Comments for Planning Application 21/00024/VAR

Application Number: 21/00024/VAR

Address: 20 Osler Road Oxford OX3 9BJ

Proposal: Variation of condition 2 (Develop in accordance with approved plans) of planning permission 20/00184/FUL (Demolition of existing dwelling and garage. Erection of 1 x 3-bed, 2 x 2-bed and 2 x 1 bed flats (Use Class C3). Provision of private amenity space, bin and bicycle stores (amended description and plans)) to allow alterations to rear roofslope and insertion of 2no. rear rooflights, insertion of solar panels to side elevation and alterations to fenestration.

21 Osler Road	Date: 04.01.2021
OX3 9BJ	Scale: 1:100 @ A3
	Status: Planning
	Drawn: RK
Proposed Side Elevations	
190278 - A - EL - 211	Revision: B

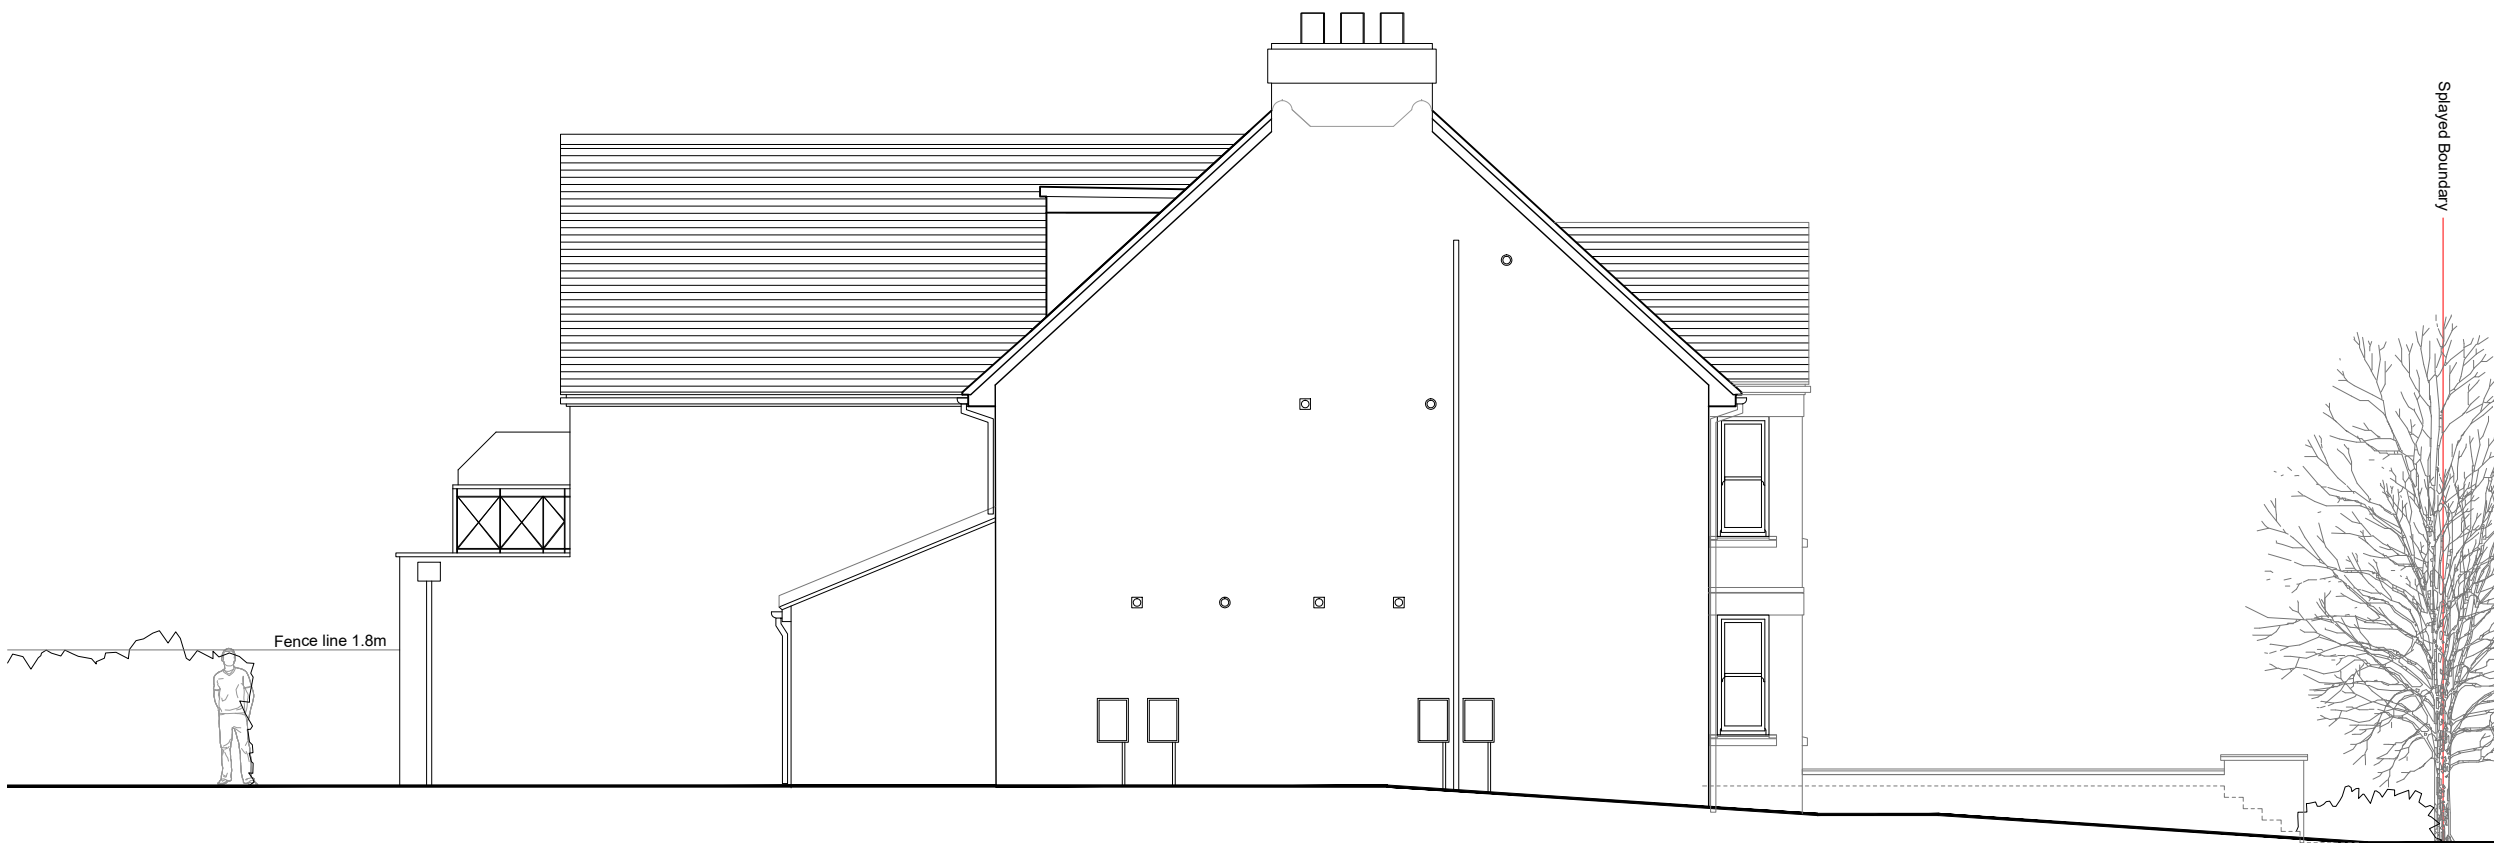
- The steeper pitch of the roof-slope will increase the overbearing nature of the development on neighbouring properties, particularly 22 Osler Road and is not in accordance with the approved plans; and

**Proposed Ground
 Floor Plan**

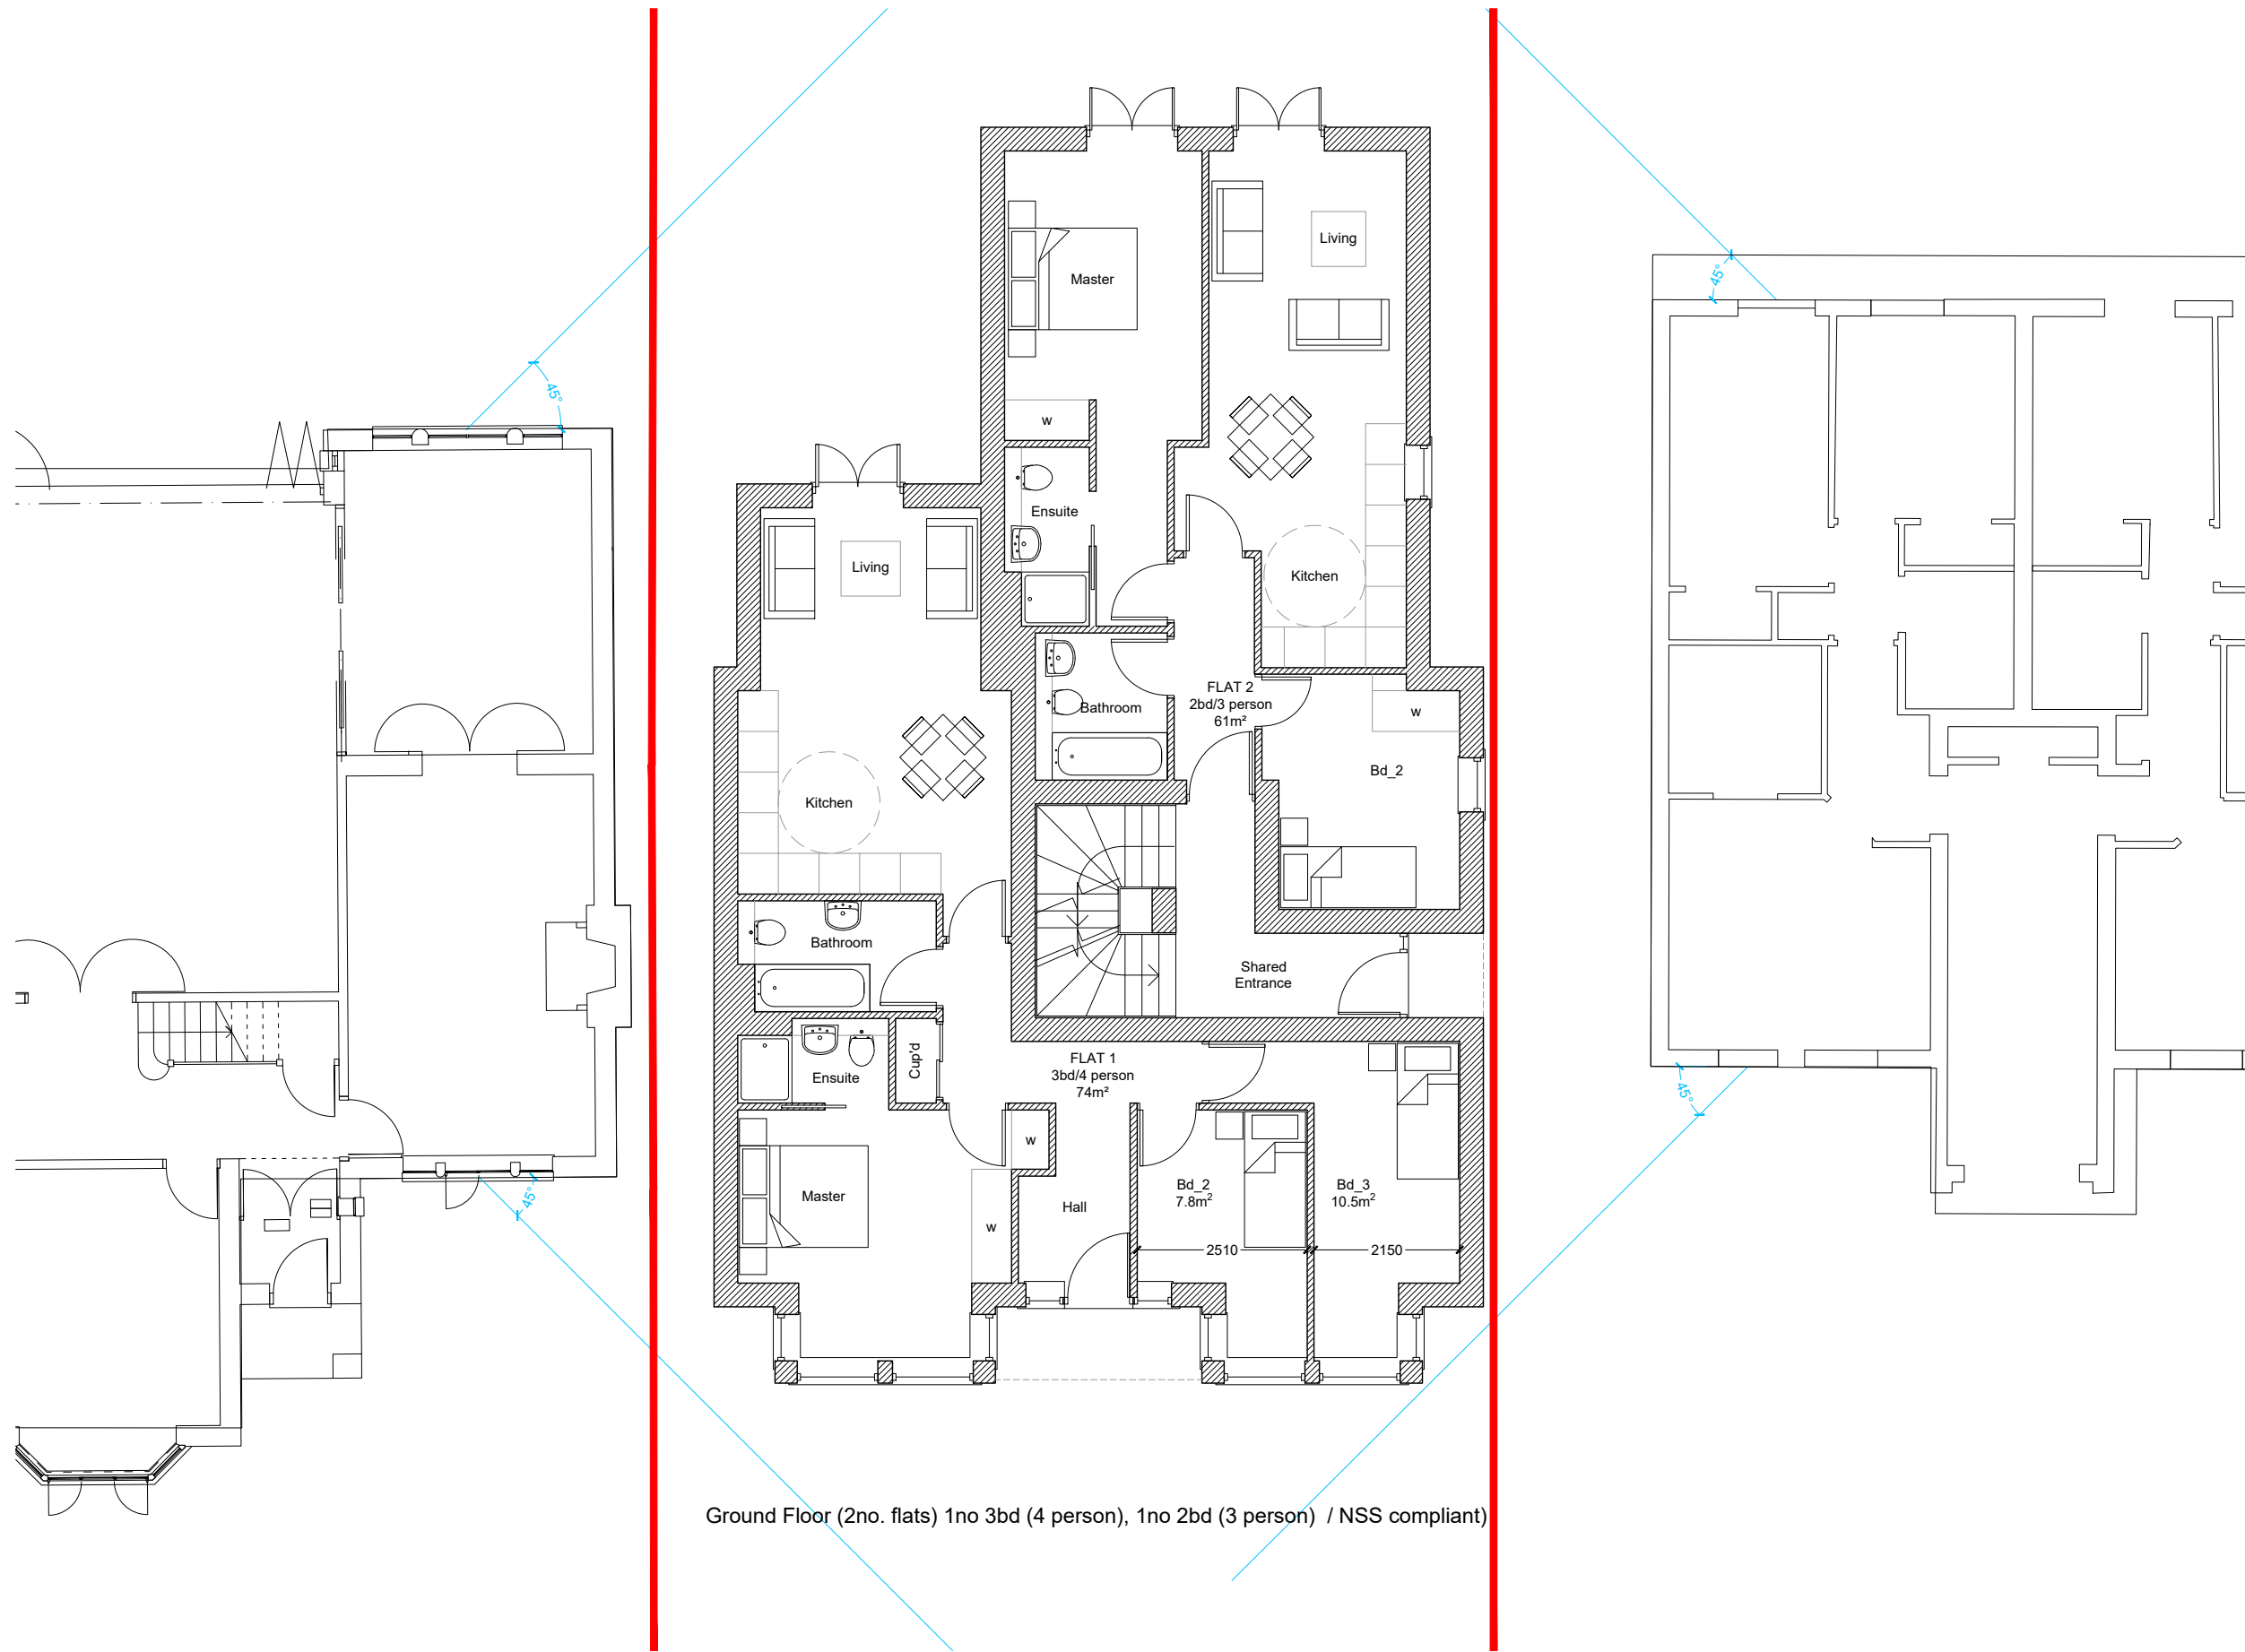
- The proposal description does not include all changes to the design applied for under this application. The building has been relocated on the plot or the footprint has been extended to the east. This is not stated in the proposal description therefore the application is inaccurate and should be considered null and void;
- No application has been made to relocate or increase the footprint of the building, therefore the
